28th November 2024

**OBJECTION TO PLANNING APPLICATION FOR ERECTION OF GARAGE WITH RAISED PATIO
(RETROSPECTIVE) AT 167 BRADLEY ROAD, BRADLEY, HUDDERSFIELD, HD2 1QF**

LPA: 2024/93151

Existing Floor Plans

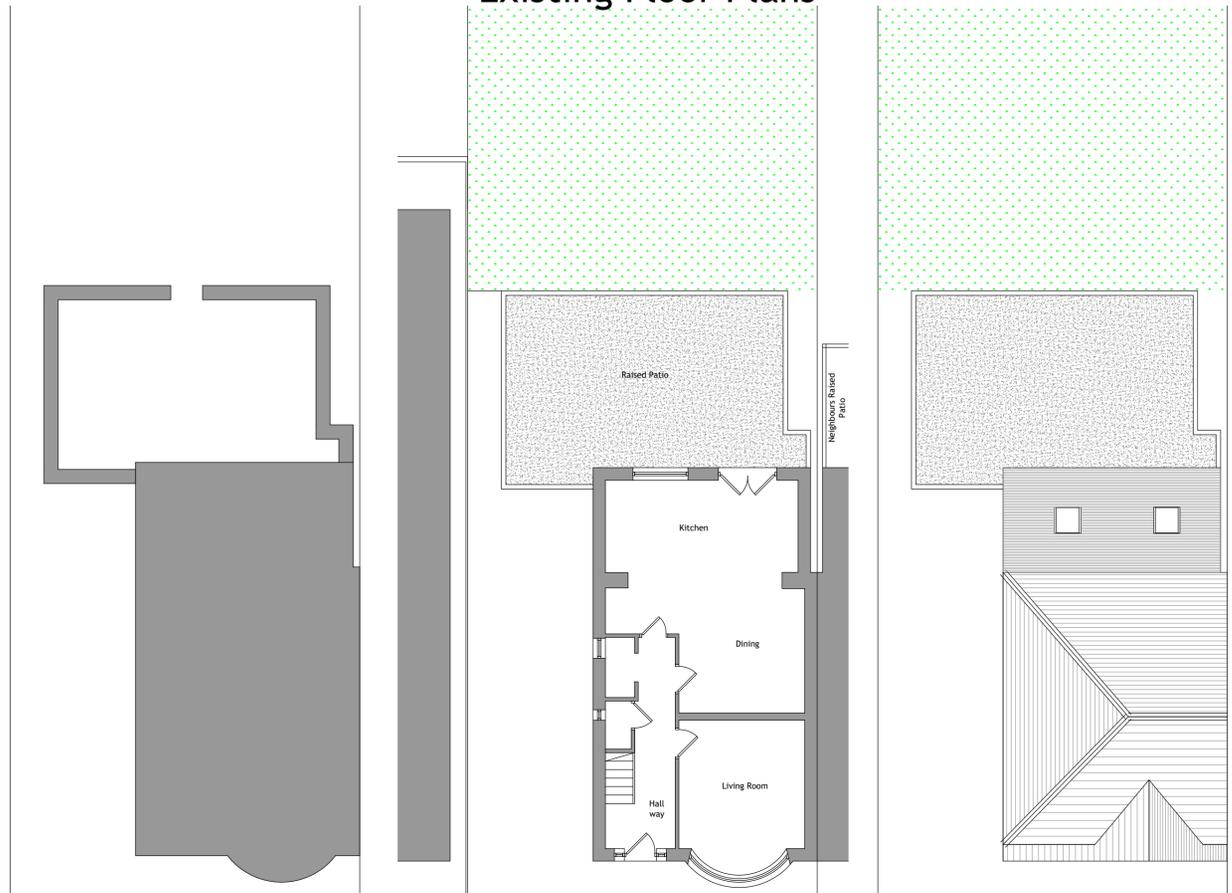
- 2) The existing floor plans and elevations are also misleading / incorrect as they include the lower ground floor extension. This element of the proposals is only ‘existing’ because the application is part retrospective. It is therefore also requested that the lower ground floor extension be omitted from the existing plans in order to reflect the true ‘as existing’ position. i.e. that the lower ground floor extension also requires planning permission and is being applied for.

Proposed Floor Plans

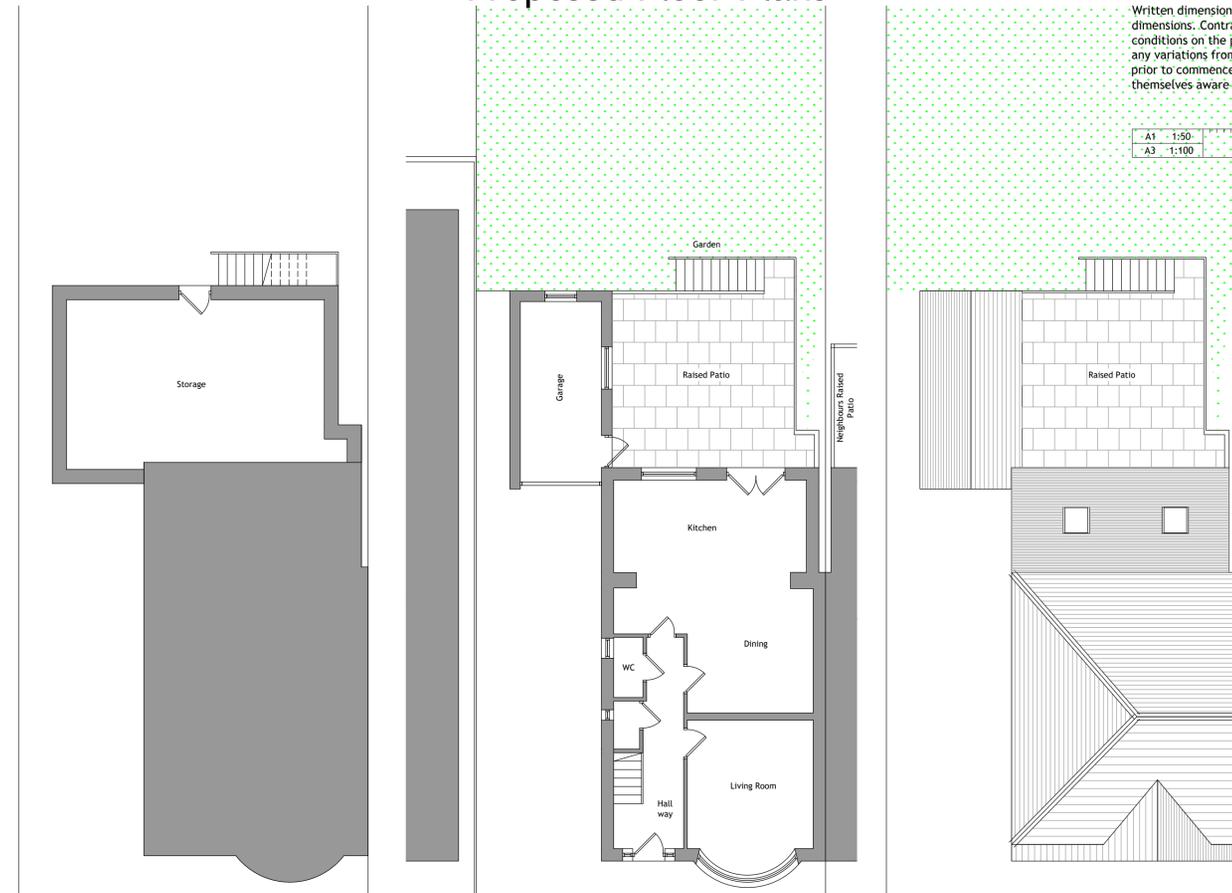
- 1) The description of the application, “Erection of garage with raised patio” is considered to be incorrect as there is no mention of the lower ground floor extension on which the garage and raised patio would be situated. The lower ground floor extension measures 8m x 5m and is therefore not an insignificant addition to the property. The extension has not received planning permission previously and would not benefit from permitted development rights as it exceeds the limitations set out in the Town and Country Planning (General Permitted Development) Order.¹ It is therefore requested that the description be amended to include “Erection of lower ground floor extension”.

- 3) The proposed garage wouldn't be able to function as a garage. Paragraph 5.15 in the Kirklees Highways Design Guide SPD states: *'For a garage to be treated as a parking space, the minimum internal dimensions should be: single garage 6.0m long x 3.0m wide.'* The proposed garage only measures 5.0m long x 2.3m wide internally. It is therefore too small. Furthermore, it is unclear how a car would enter / exit the garage given it is meant to be built on the raised patio (see photograph below). It is therefore requested that clarification is sought on this issue.

- The existing single storey rear extension projects out from the rear wall of the original house by 3 metres. The proposed development would extend out by an additional 5 metres giving an overall projection of extensions from the rear wall of the original house of 8 metres.
- The proposed development not only projects out by more than 3 metres, but the eaves height of the garage element, when measured from ground level, measures 4.9 metres and therefore exceeds the 2.5 metre allowance.
- The gap between the proposed development and the shared boundary only measures 0.76 metres.

East Elevation (Side) 1.100 South Elevation (Rear) 1.100

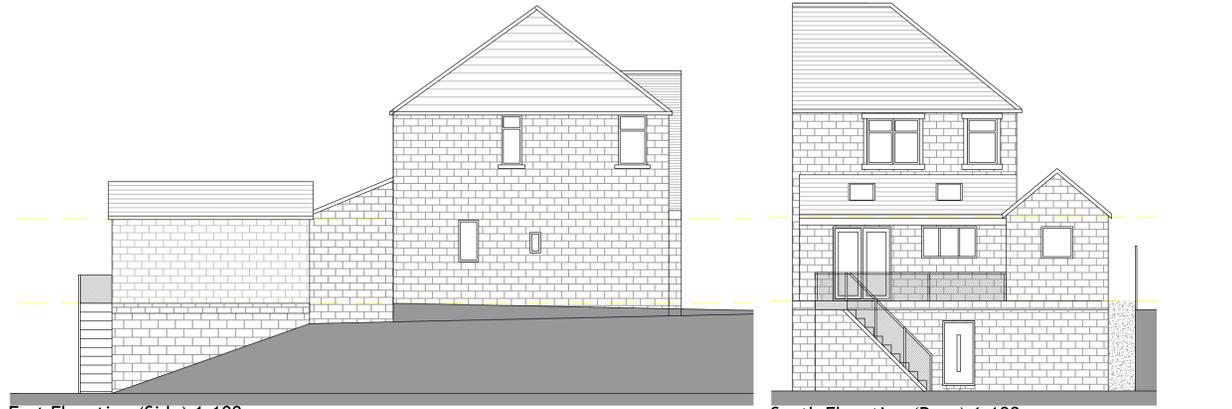
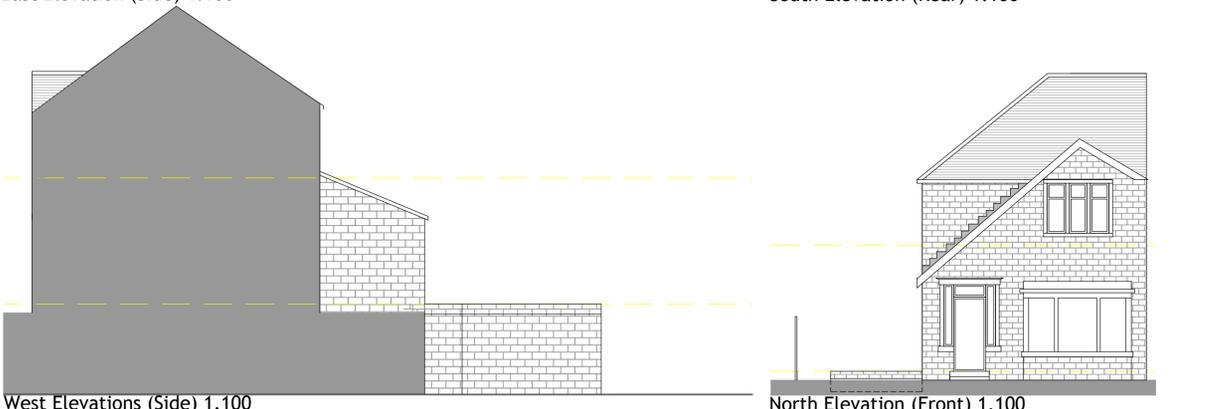
the height of the proposed raised patio exceeds the height of our clients’ boundary fence quite considerably. Should the garage element of the development not be constructed, the raised patio would result in significant overlooking and a loss of privacy for our clients when they are out in their garden. Even if the garage is constructed, the height and depth of the raised patio would still cause a degree of overlooking and loss of privacy to an unacceptable level.

The garage is proposed to be built on the raised patio, which, as stated above already exceeds the height of our clients' boundary fence. Our clients' property is a detached single storey dwelling, and as such, the overall height and close proximity of the proposed garage to our clients' house and garden would have an overbearing impact and reduce their outlook when they are out in their garden.

The original house is a modest two-storey semi-detached property constructed of natural stone. By contrast, the proposed lower ground floor extension essentially comprises a large (5m x 8m) concrete block with no windows or architectural detailing. Even when completed, the development, including the raised patio and detached garage, would result in an intrusive and incongruous feature that dominates the original house and is not in keeping in terms of scale, materials or details. It is considered the development would have a detrimental impact on visual amenity and local character.
